RESERVED MATTERS

Reference: H18-0367-25 **Date of Decision:** 5th June 2025
Applicant: Mr & Mrs J Cooper
Clementine Cottage
56 New Road
Sutton Bridge
Spalding
PE12 9RQ
Location: Adjacent To Rylton House Mill Lane Sutton Bridge Spalding
Description: Residential Development of 2 dwellings - Outline Approval H18-0241-22

Job Ref.	Drawing No.
4374-25	02.

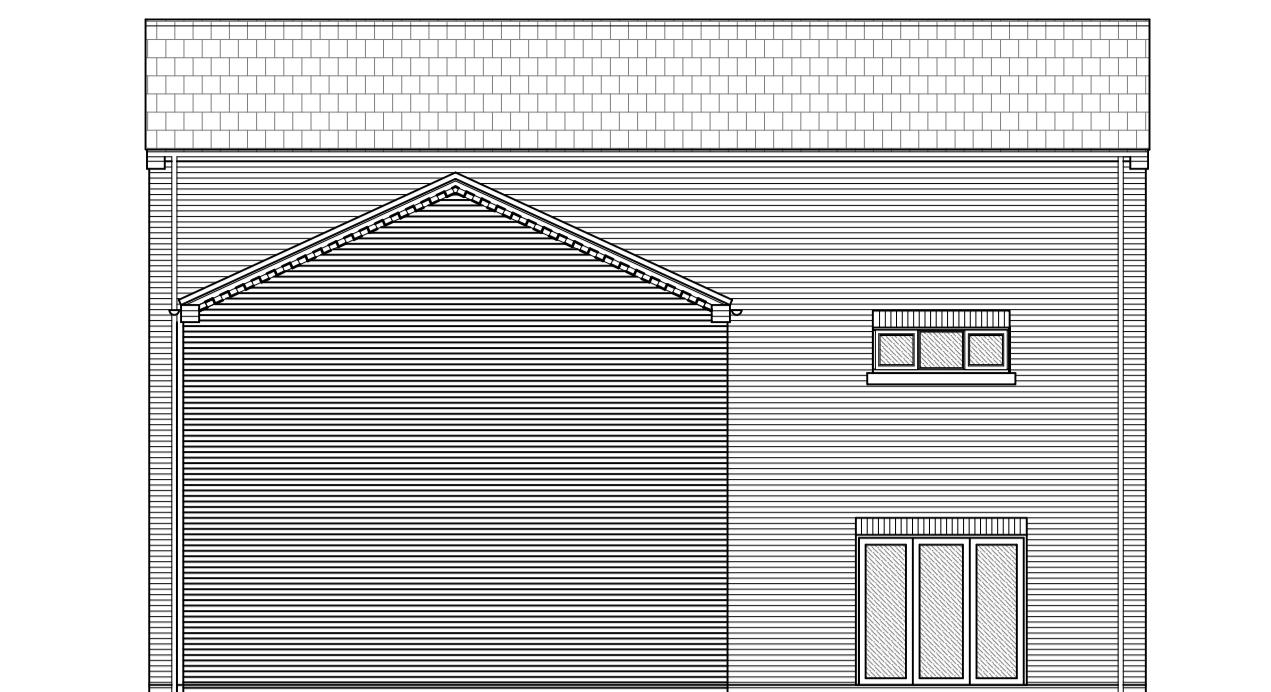
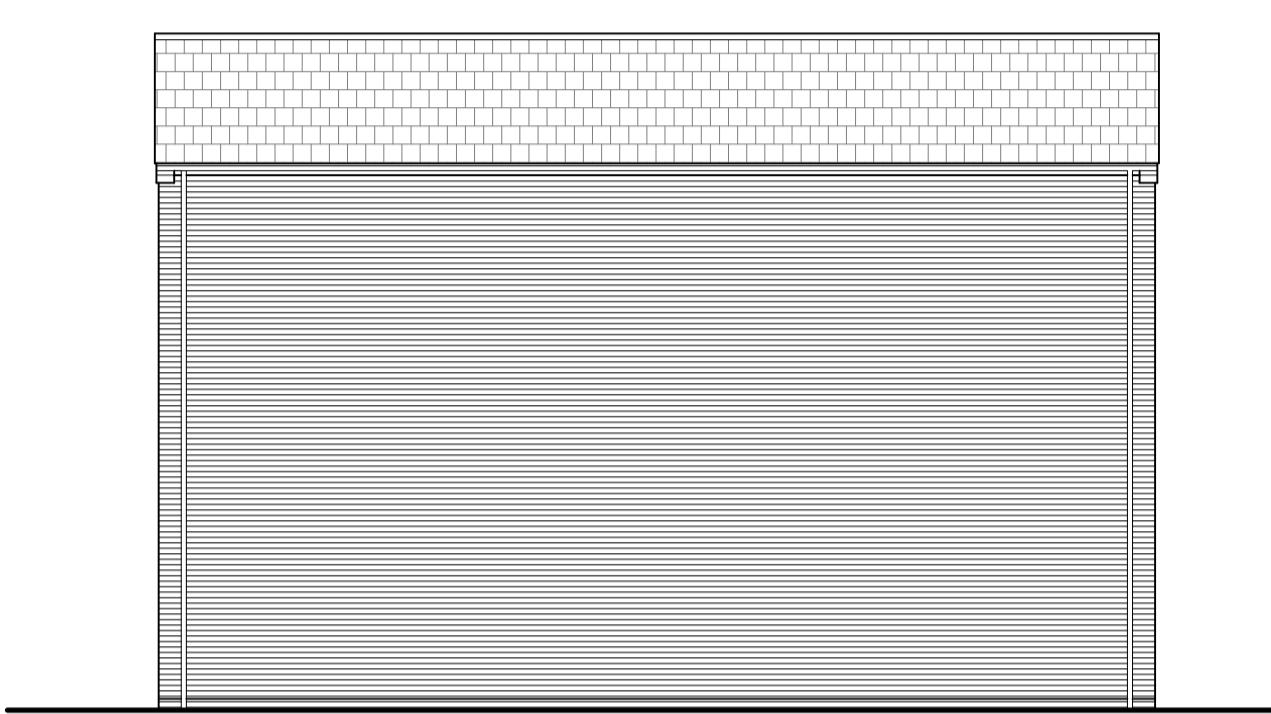
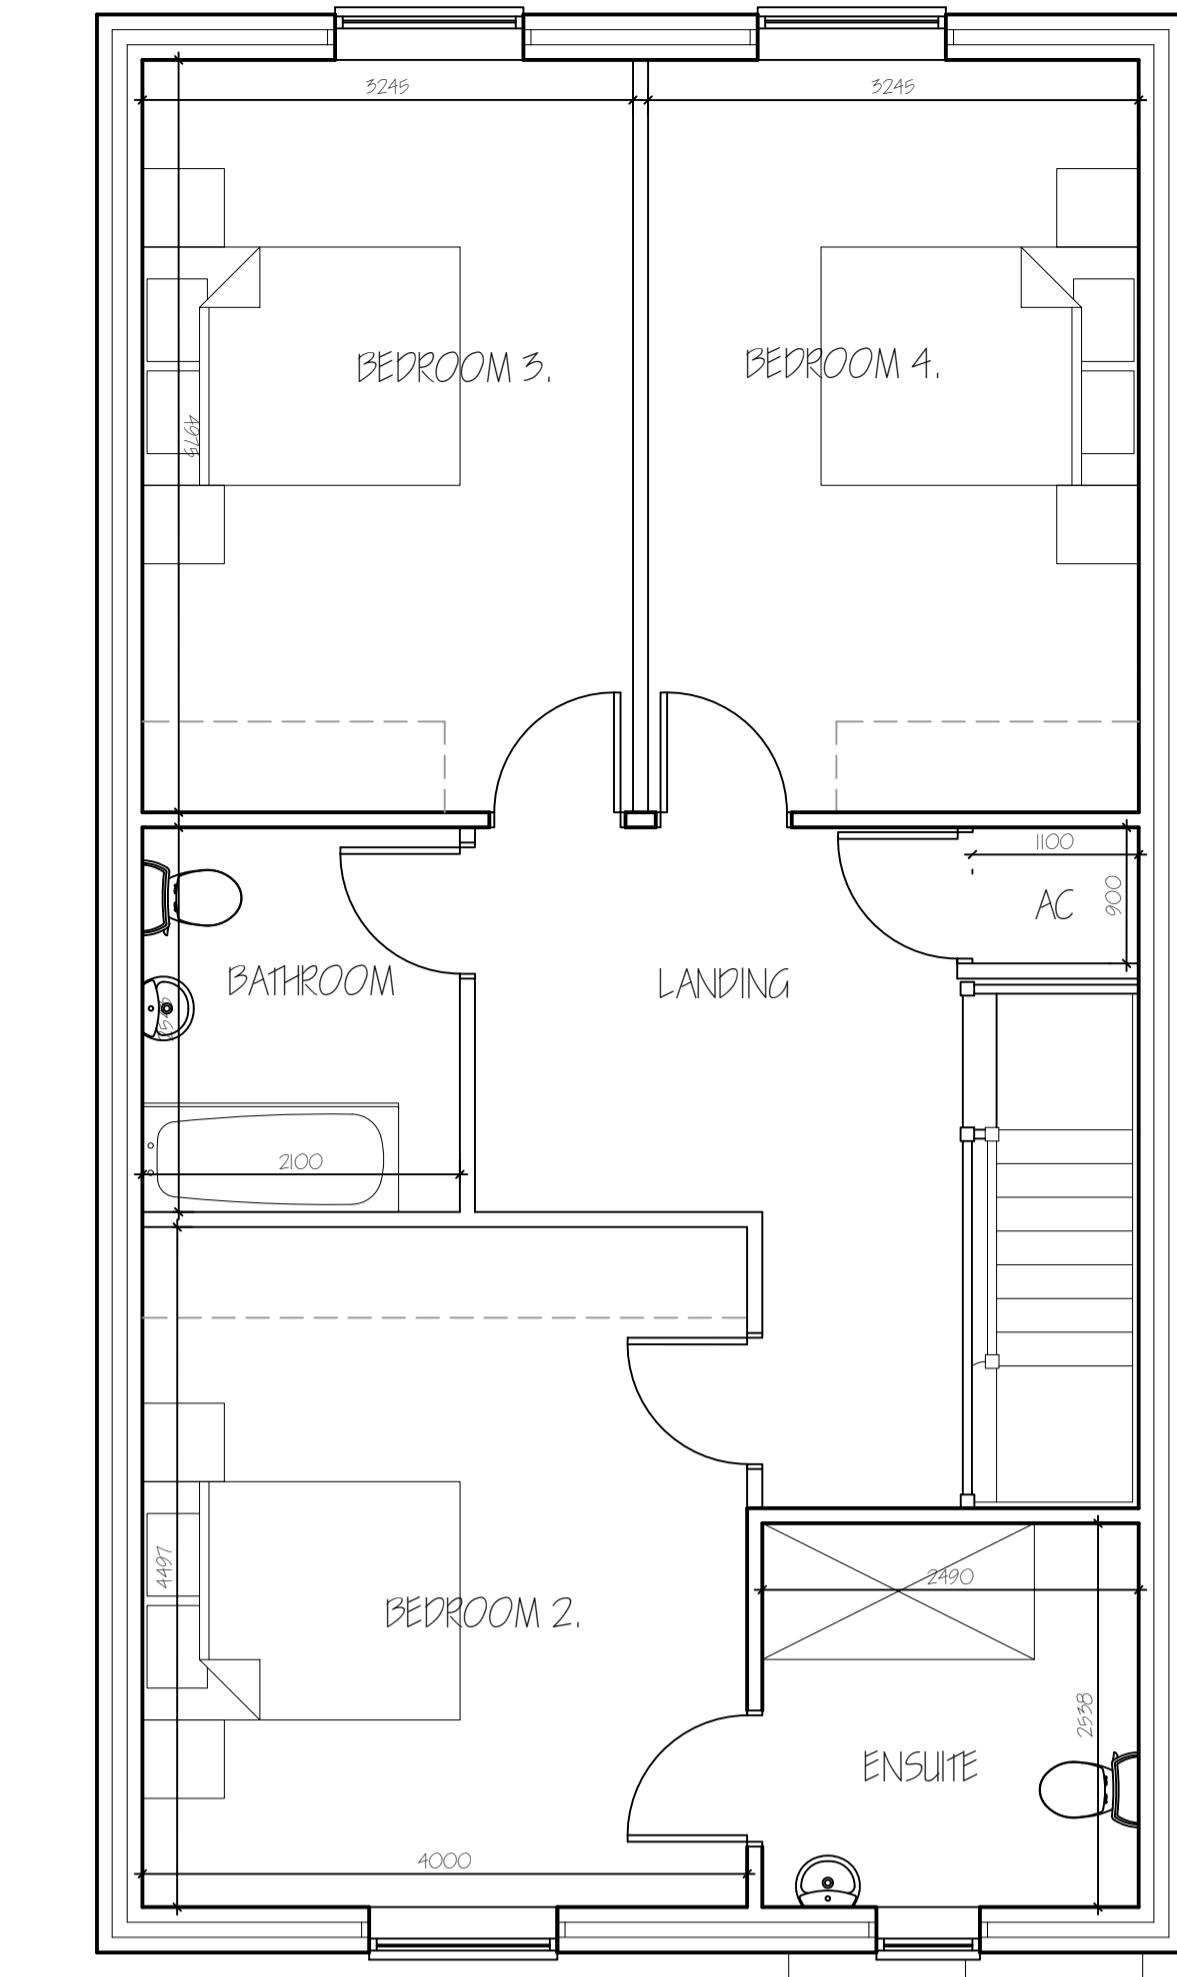
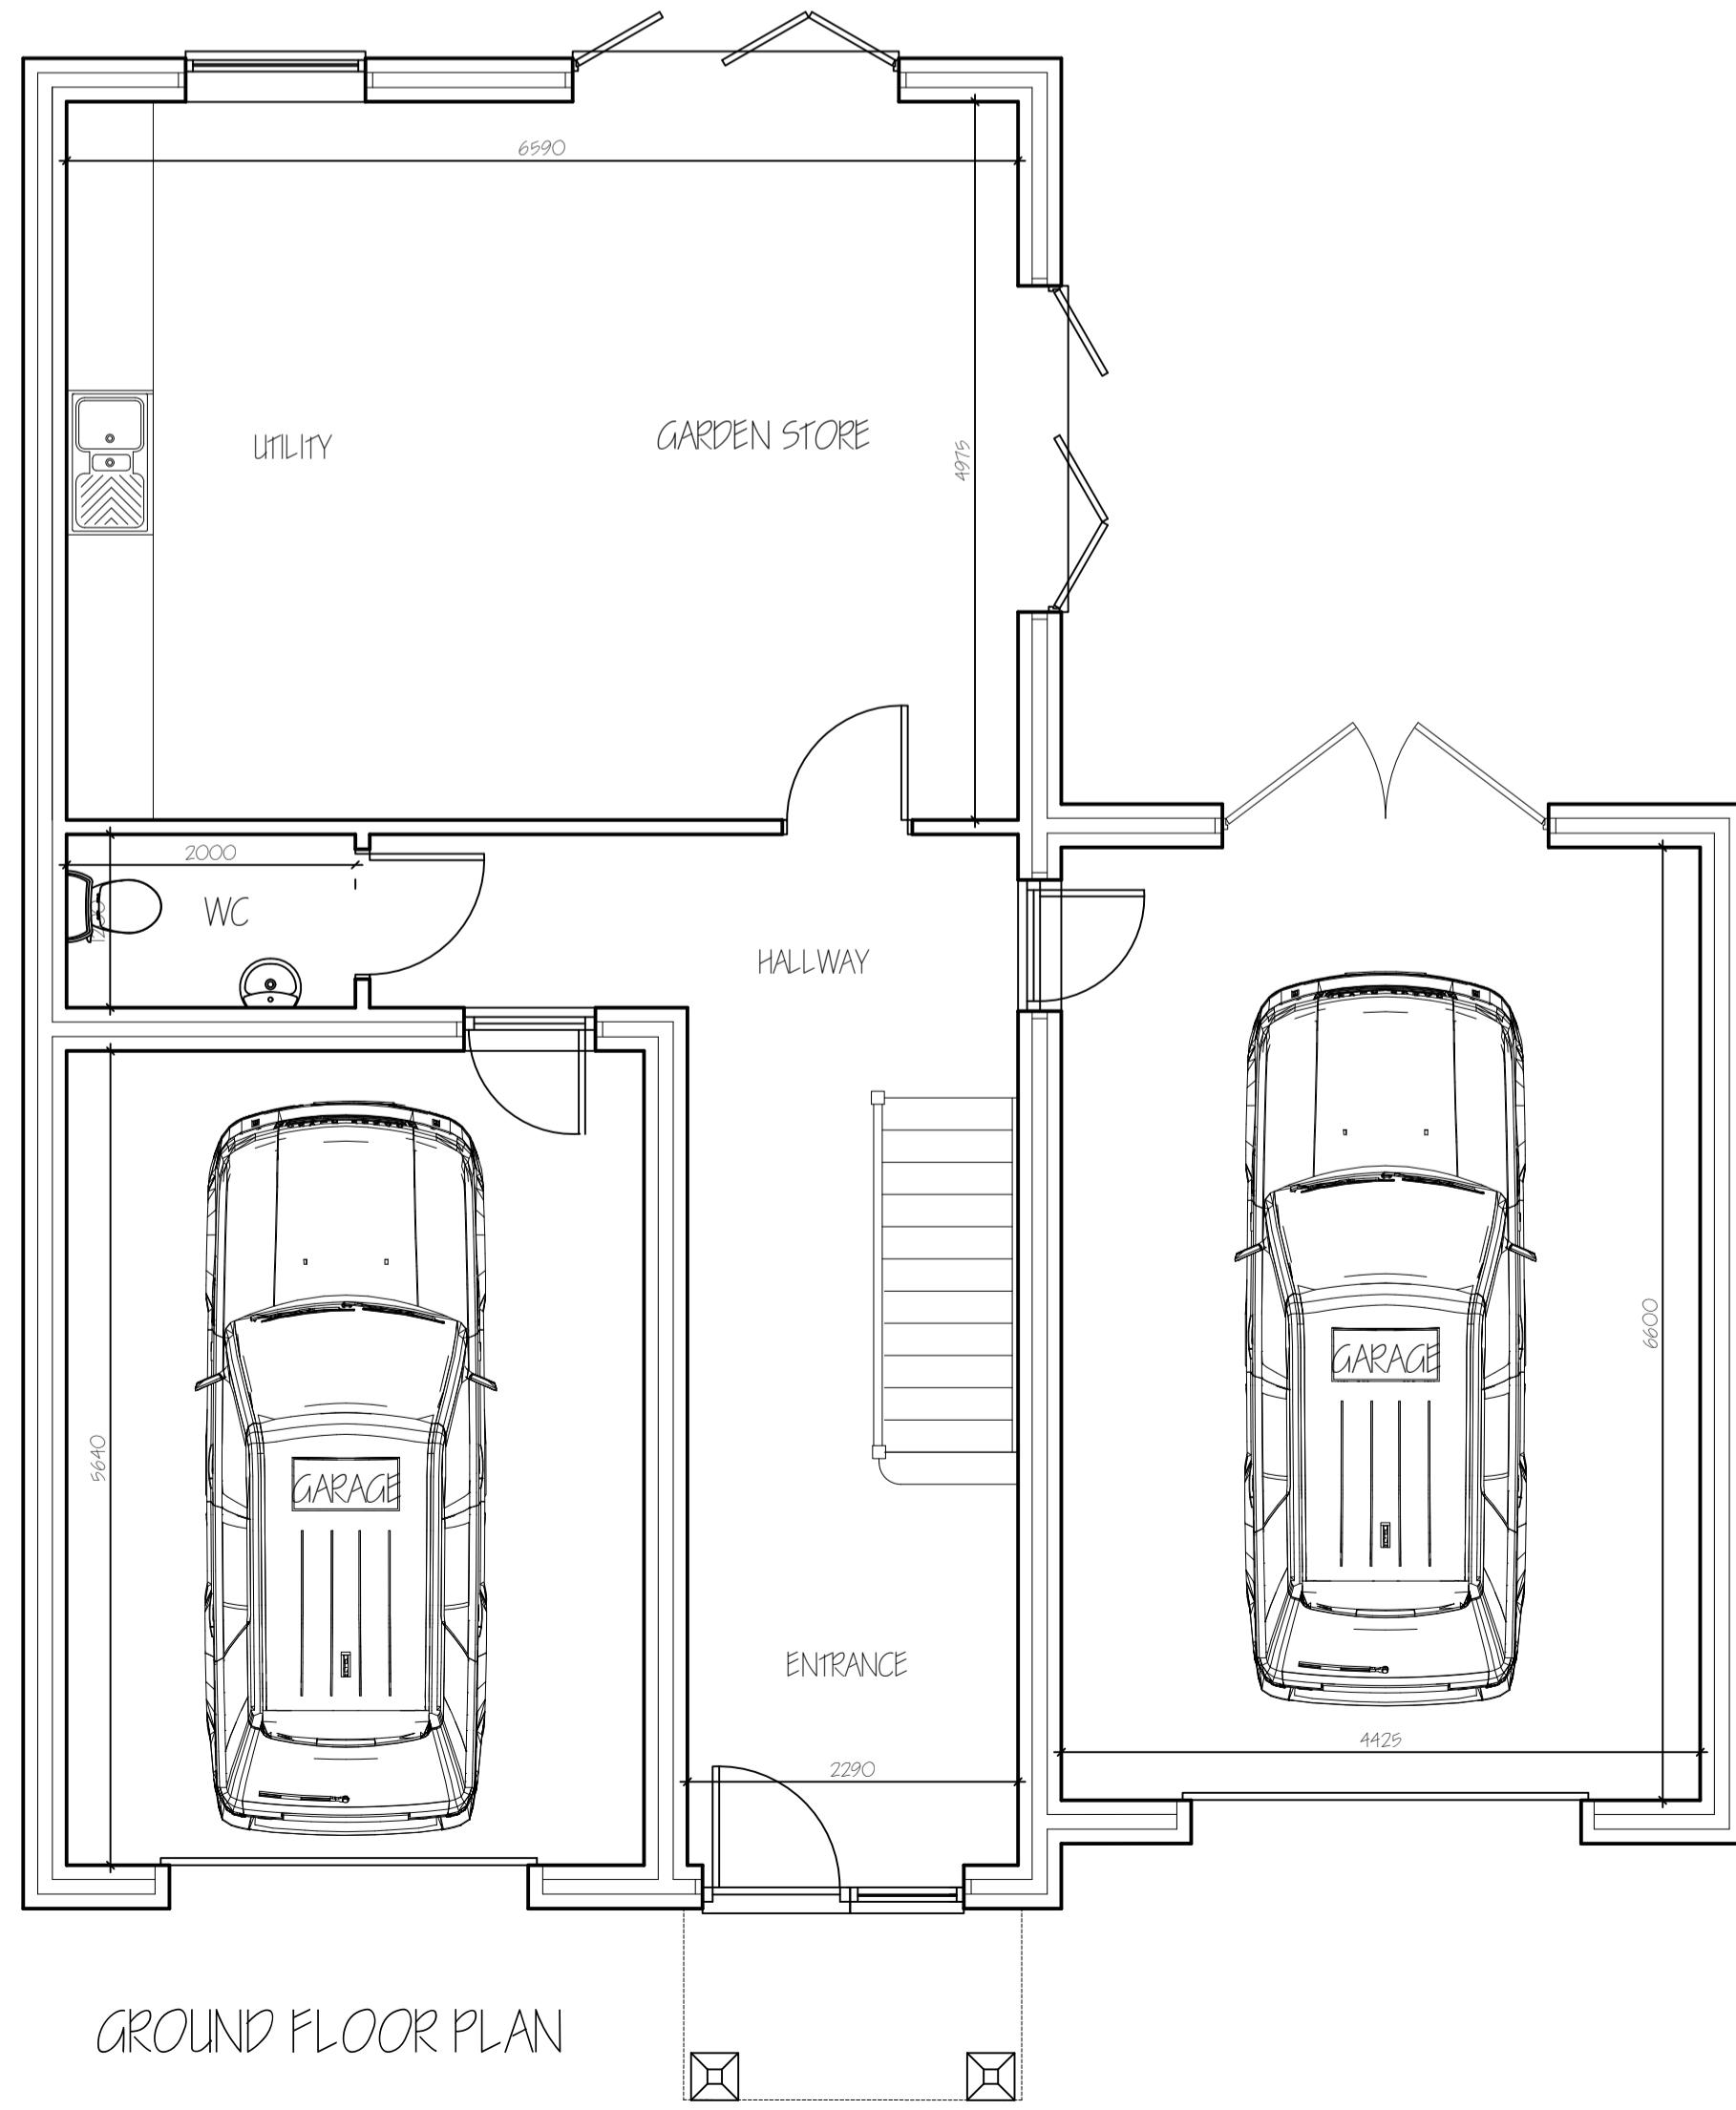
- 1 The proposed dwellings by virtue of their scale, massing, siting and appearance would be at odds with the existing character of the area and would result in an incongruous development, that would give rise to an unacceptable impact upon the character of the local area.

- 2 The scale and massing, along with the proximity of the 3-storey dwellings, sited next to bungalows, would have an unacceptable overshadowing and overbearing impact on neighbouring amenity.
